**Re: Application No. 3/2023/0540, Planning Meeting 30 May 2024**

Re:- Application No. 3/2023/0540.

This letter is concerned with the eastern 'open space' area with pond, footpaths and planting/landscaping as approved in 3/2011/1071.

Drawing Reference:
Master Site Plan

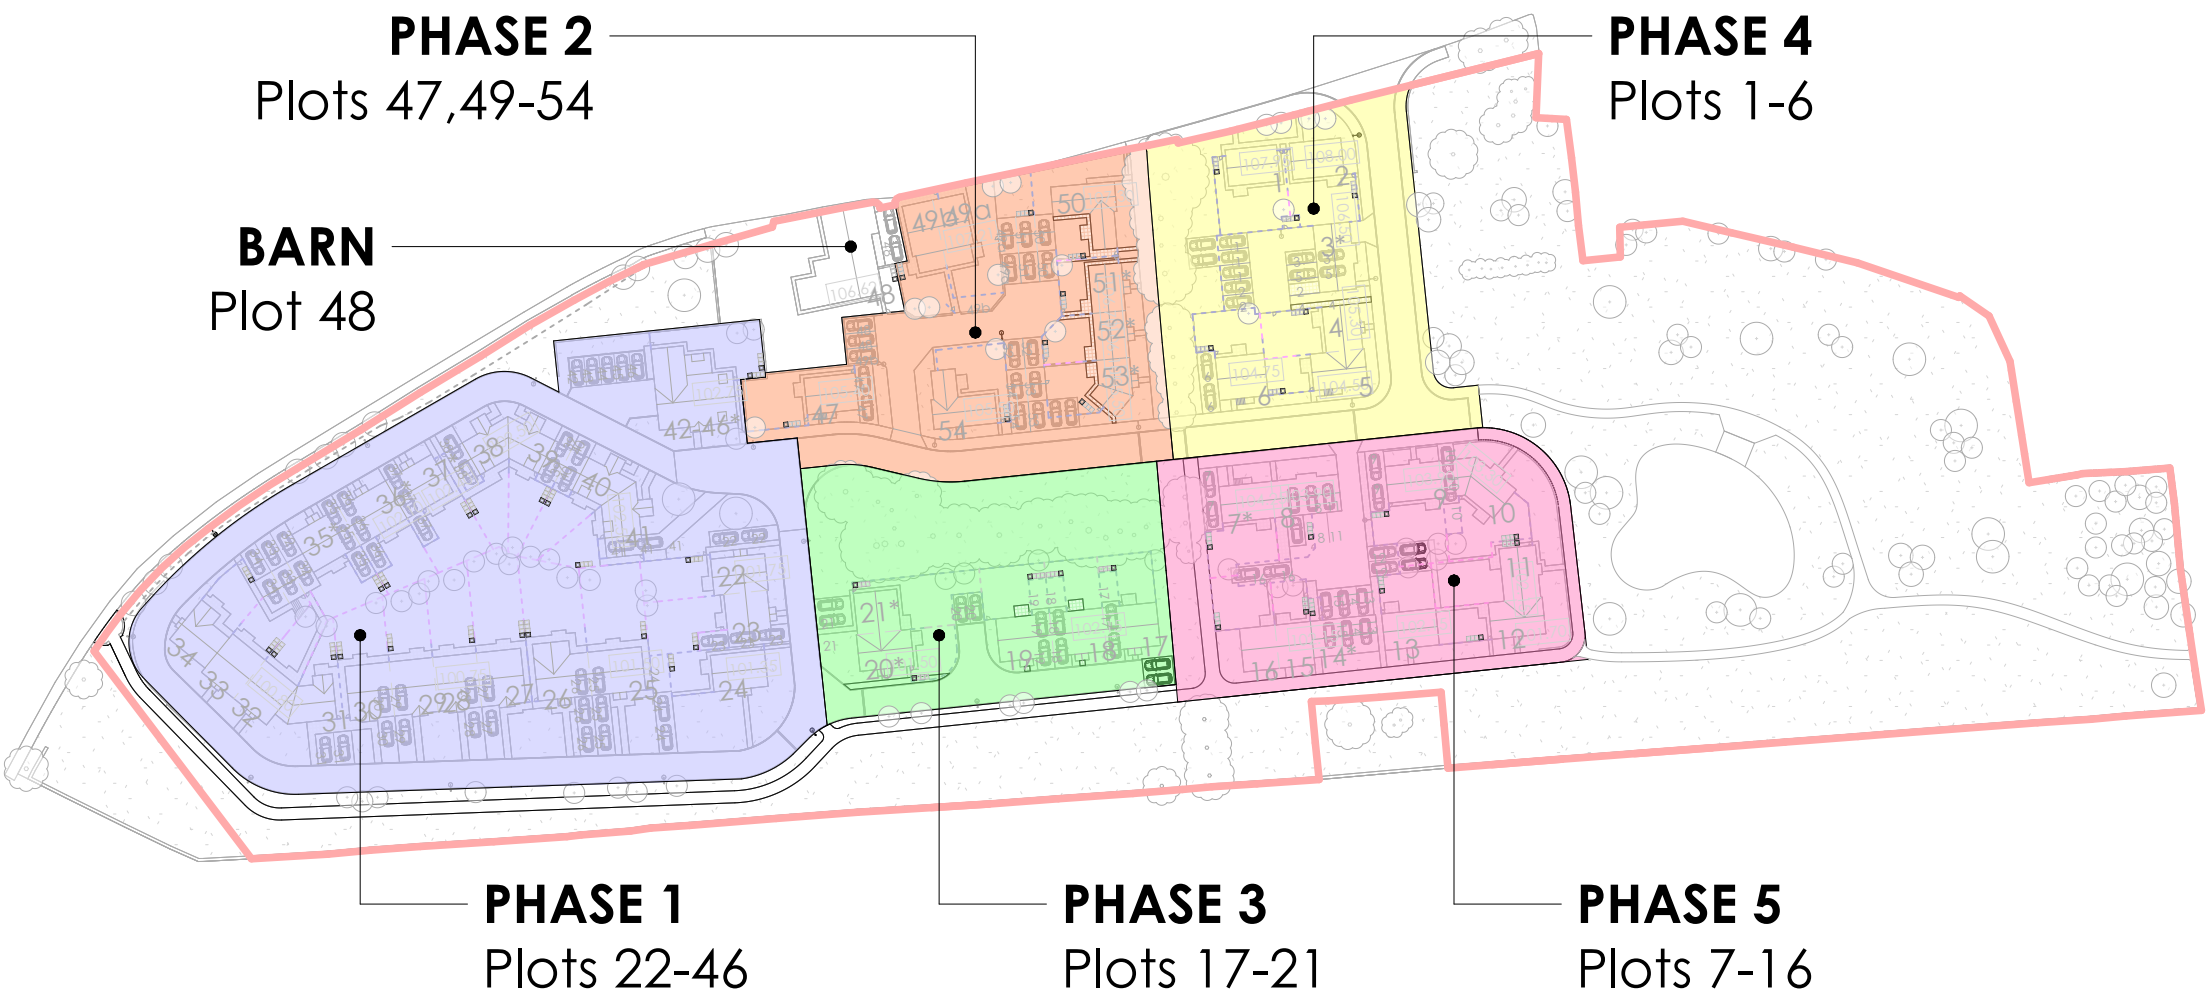
Firstly, the area to the Eastern side of the development should be clearly defined as a "Public Open Space," in order to reflect Local Planning Policy for developments of this size, rather than just an "open space." It is difficult to ascertain what is being proposed as the on-going status for this area as plans seem to be continually changing and it is difficult to ascertain the status of the plans on your web site. One of my neighbours has written to your department (Lyndsey Hayes) separately regarding this. Based upon the original Planning Approval it is expected that this area will indeed be designated a "Public Open Space" or at least designated in a way that protects it's "Public Open Space" status for future generations. It would be helpful if, before a revised recommendation is submitted, you could clarify what the status of this area will be.

Secondly, the pond included in the originally approved plans was an important ecological feature as well as being for drainage purposes. If I understand the latest proposal, it would appear that the pond is to be reinstated. Whilst I recognise the acceptance, by United Utilities, that the drainage benefit of the pond can be achieved by using the Chapel Brow culvert, I have been advised by an architect involved in the developments in Grimsargh that this culvert may eventually discharge into Tun Brook and go through an area in Grimsargh that has been prone to flooding. You might want to seek reassurance from United Utilities that such flooding would not be a risk, before such approval was given.

Finally, a number of properties in Chapel Brow enjoy right of way access to the rear. I would hope that the detail of the final plans allow for sympathetic treatment to these access rights and that this area can be fenced off as it has been for at least 50+ years and is the case at present.

The recent spate of 'revised Plans' with the most recent being Rev 'X' shows two views of the eastern side of the site and is titled 'green spaces comparison plan'. On the left drawing titled 'approved green space plan' it clearly states that it is **APPROVED** in application No. 3/2017/0981. Permission is now sought, on the right hand drawing, that removal of the pond be approved.

Interestingly Plan Rev. 'O' shows the footpath layout in the open space as winding through the site in a convoluted manner that appears totally without logic. The sudden appearance of a new length of footpath alongside the east of the access road and the new path connection is to the South of the originally approved footpath layout.

The increased exposure of pedestrians who will now be forced to walk along the narrow access road albeit on a new footpath which also does not seem to be approved! This is another example of error in their statement about No.0981 How interesting!
